Submission Regarding the Proposed Dubbo Zirconia Project

The following provides the submission of Taronga Conservation Society Australia (TCSA) in relation to the Environmental Impact Statement for the proposed Dubbo Zirconia Project.

OBLEY ROAD ALIGNMENT INVESTIGATION & INTERSECTION TREATMENT CONCEPT

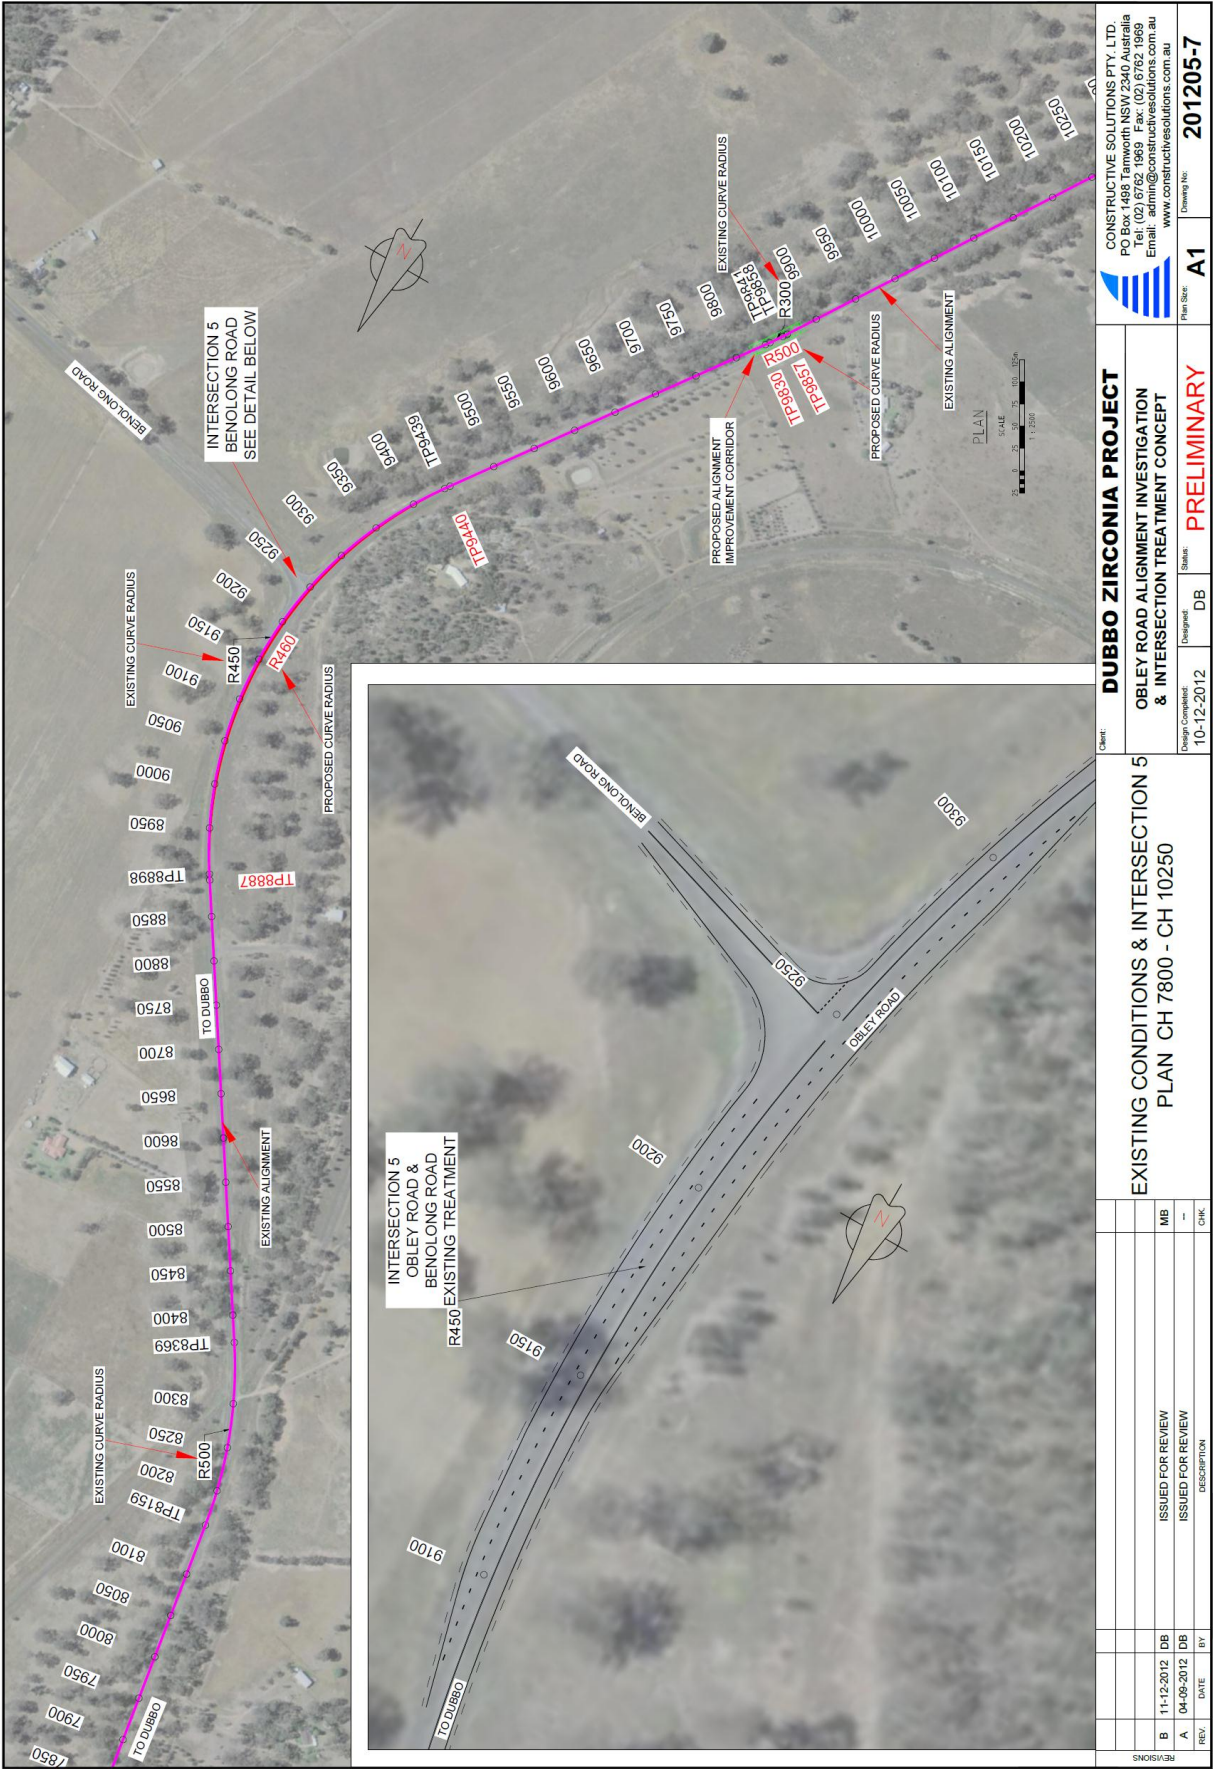
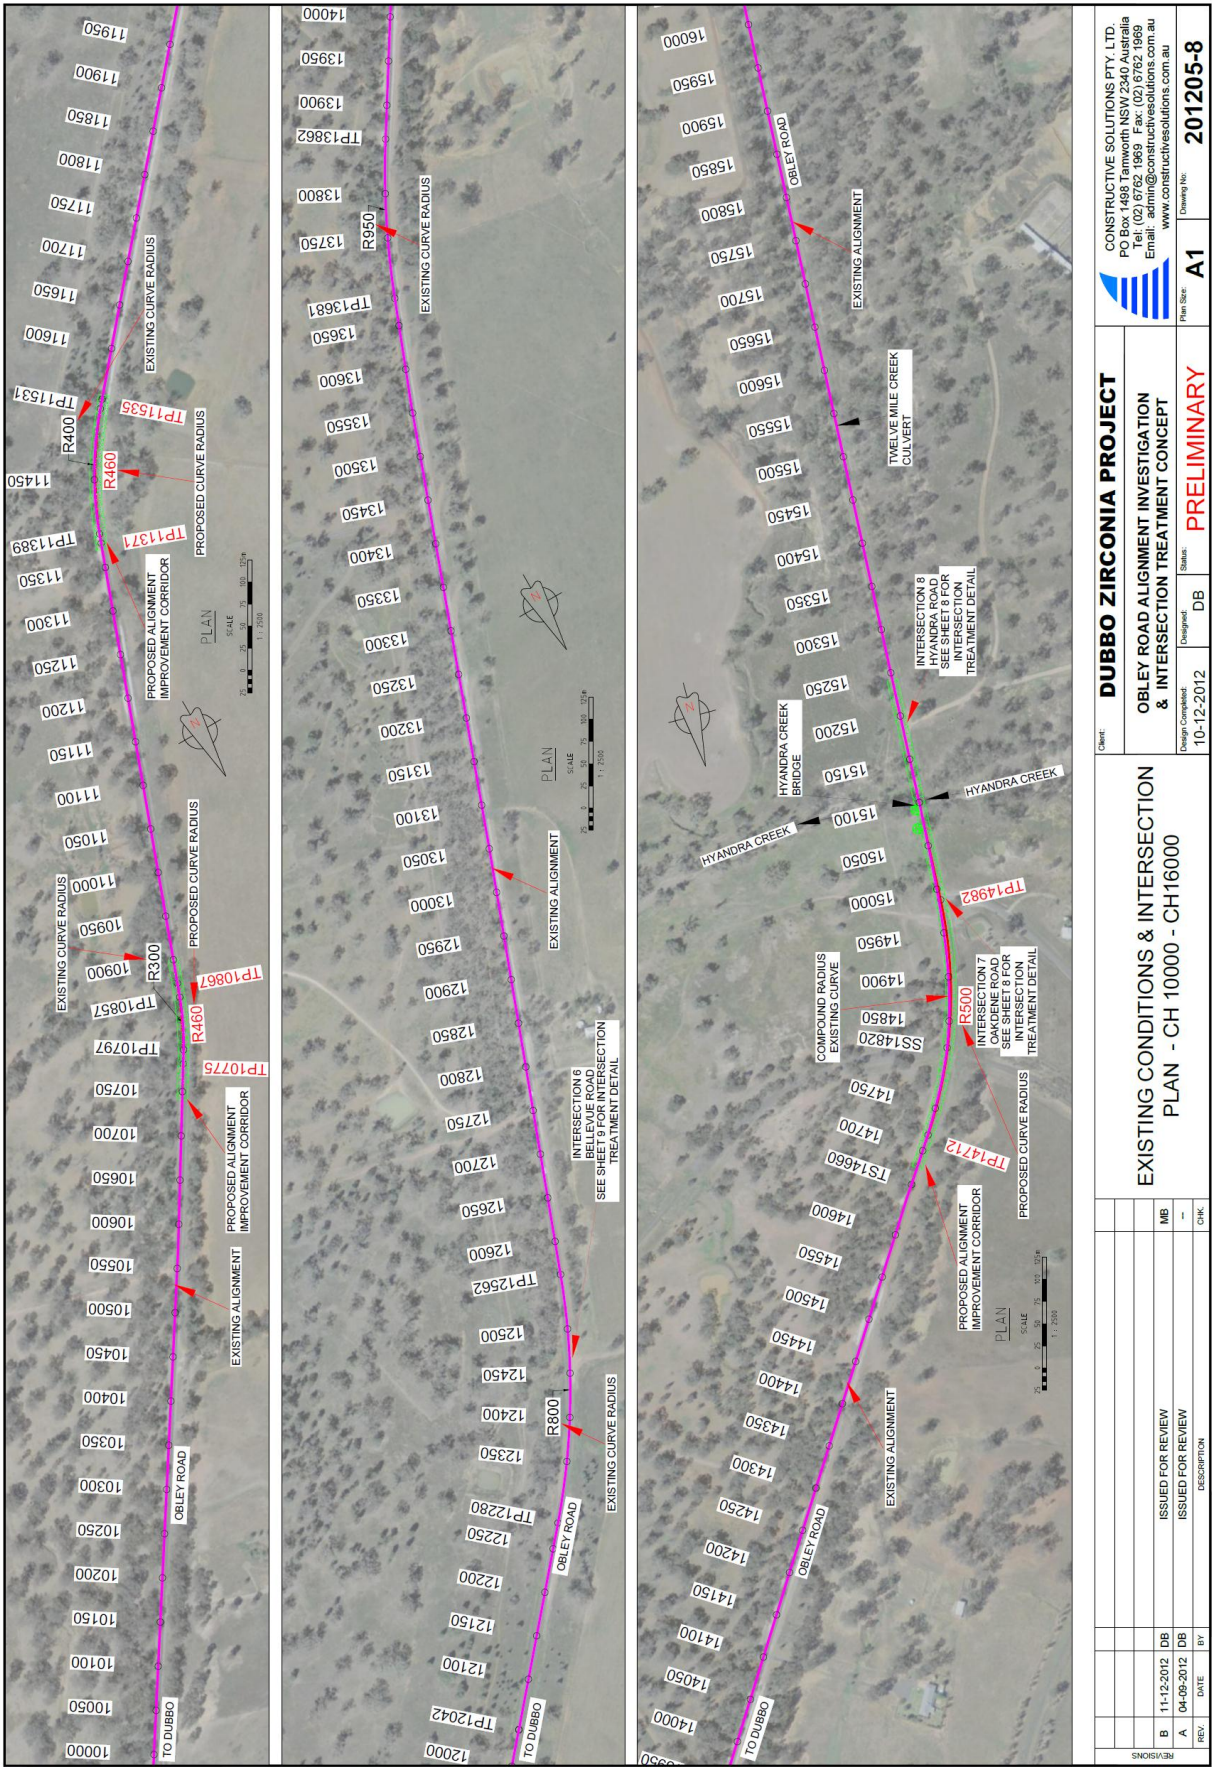
The EIS indicates that there would be various upgrades to Obley Road under the proposal, including alignment adjustments to meet Austroads *Guide to Road Design* requirements for a 100km/hr speed limited road, pavement improvements, and the establishment of a 9m wide pavement seal. No specific improvements to Obley Road adjacent to the main operational area of the zoo, are indicated in Figure 2.4 of the EIS

It will be vital to minimise the risk of conflict between vehicles associated with zoo visitation and those associated with the proposal. TCSA therefore suggests that the standards to be adopted for Obley Road between the Newell Highway and the zoo entrance, should be higher than those adopted for the remainder of Obley Road. Specific improvements requested by TCSA for this section of Obley Road are:

- The establishment of a standard 12m wide road cross section based on Austroads guidelines for roads carrying more than 3000 vehicles per day. This would comprise 2 x 3.5m wide lanes in each direction, 2 x 1.5m wide sealed shoulders, and 2 x 1m unsealed shoulders on the outside of the sealed shoulders.
- Clear road and edge line delineation.
- Addressing the presence of clear zone hazards such as trees (potentially through minor adjustments to the road alignment and/or safety barriers)
- Upgrading of the cyclist/pedestrian crossing on Obley Road near the zoo entrance. The most appropriate solution may be grade-separation

TCSA also requests that pavement upgrades are undertaken along Obley Road between the Newell Highway and Camp Road to create a consistent high quality surface along the entire length of this section of road. We would like consideration to be given to the use of low noise pavement as part of any pavement upgrade.
